Re; Planning application EP / 7 / 18 / PL

OBJECTIONS TO PLANNING APPLICATION EP/ 7/18/ PL

**LAND TO REAR OF BEECHLAND "COTTAGES"/ NORTHERN PARADE OF SHOPS
EAST PRESTON**

DRAWING TITLE
Proposed Site Plan, Block Plan
and Location Plan

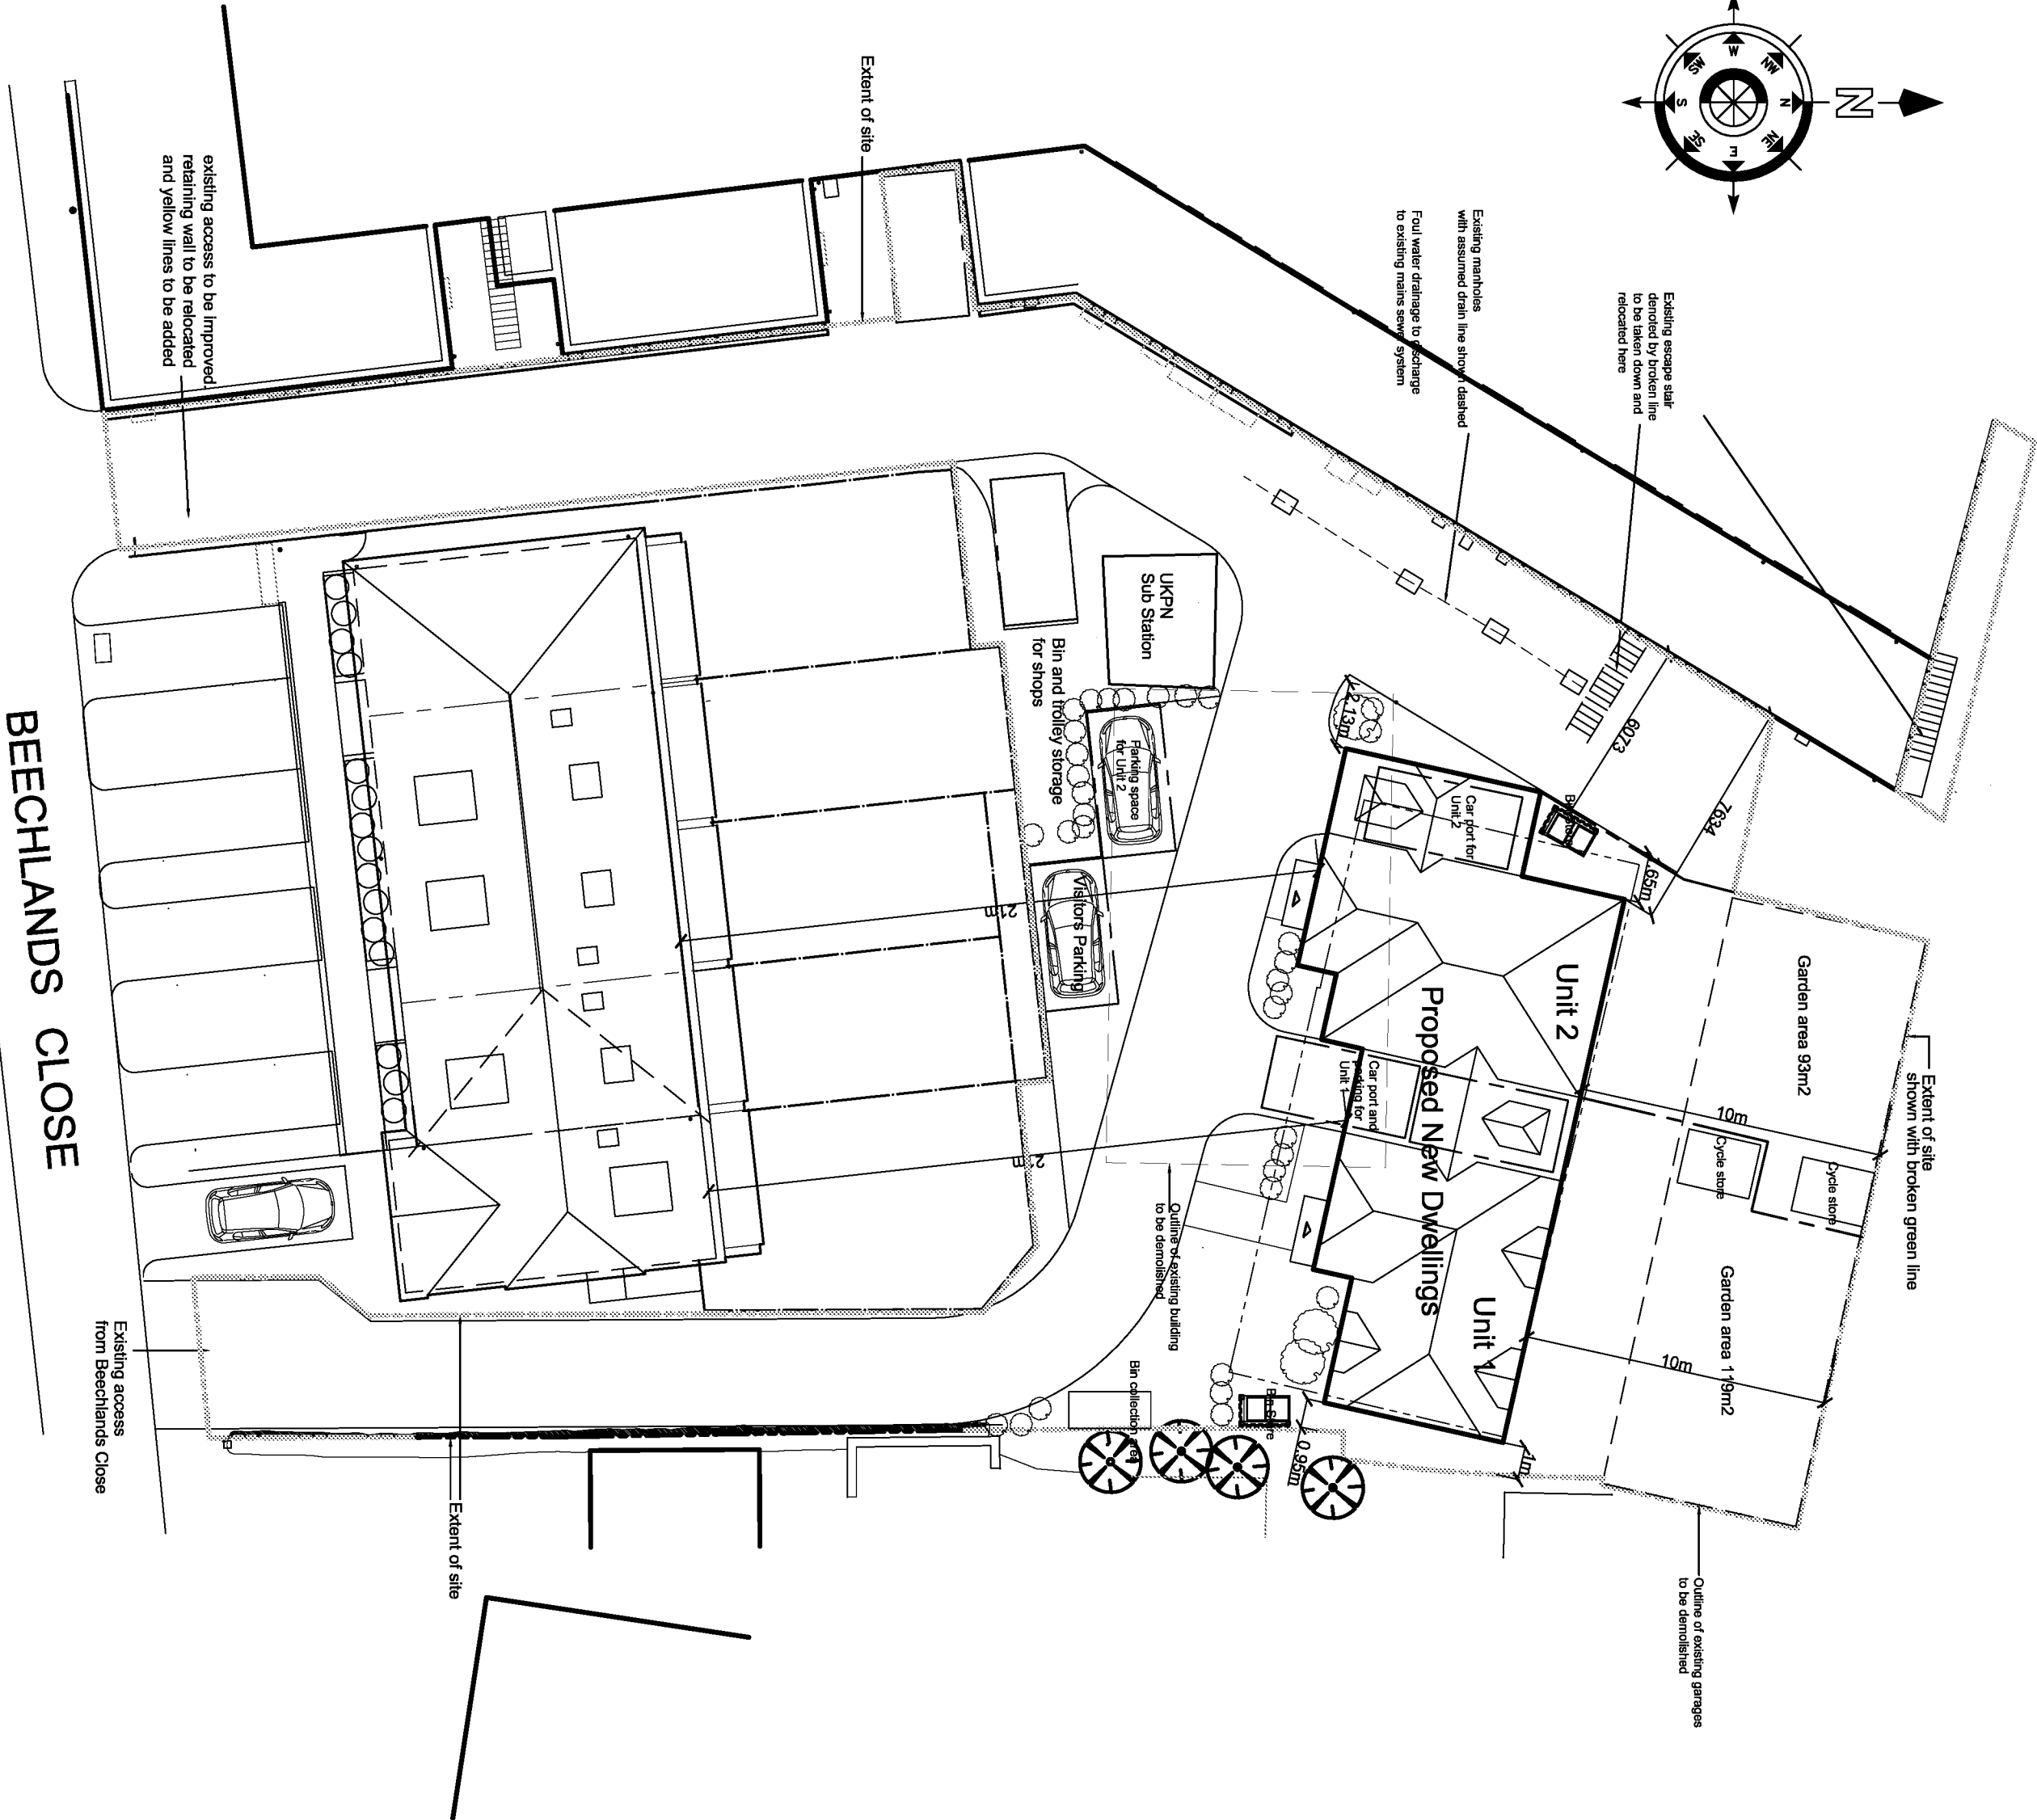
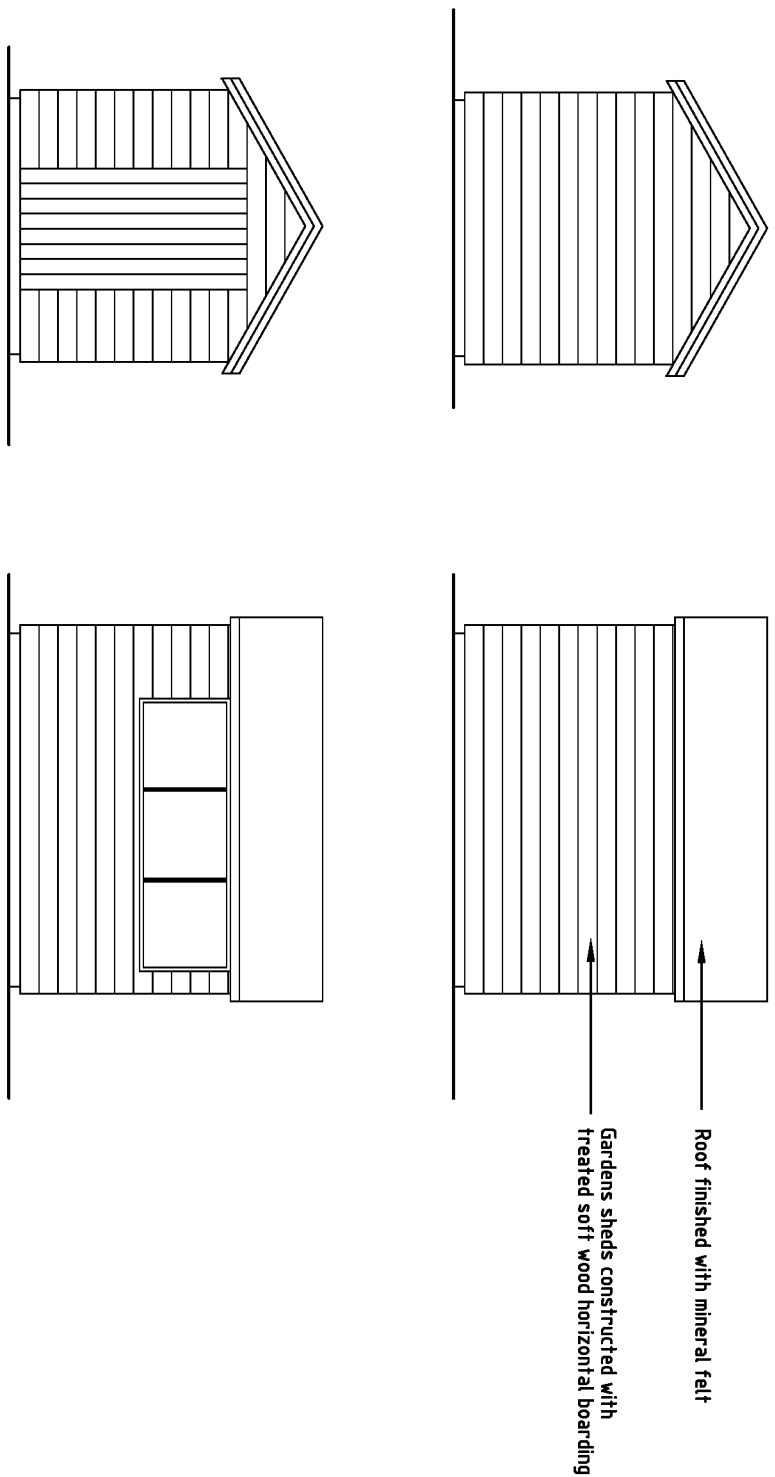
The proposed development seeks to severely restrict the vehicular and pedestrian access route to our property making it difficult to ingress and egress safely for us, family, friends and deliveries all of whom are entitled to do so, insufficient provision has been made for large vehicles having driven in to turn around safely reversing out would be hazardous.

The severely restricted route with tight bends and radii to Beechlands Close would be impossible to negotiate when towing our race trailer or when friends and family visit either in their motor homes or other vehicles as they do so at present. Passing arrangements are inadequate when confronted with vehicles coming in the opposite

No provision has been made for our pedestrian visitors or others using this now narrowed route with regards to their safety either by way of a pavement or lighting. There is no consideration on the plans for parents with children in prams or the elderly when confronted by motor vehicles.

The current area behind the shops owned by Eurosite Ltd shows "existing access to be improved, retaining wall to be relocated and yellow lines added but no explanation as to why .

Is this the new or altered vehicle access proposed to or from the public highway ?.. or are there no new public roads to be provided within the site ?

If so, what provision will be made for pedestrians and the two different landlord's tenants using this route ?
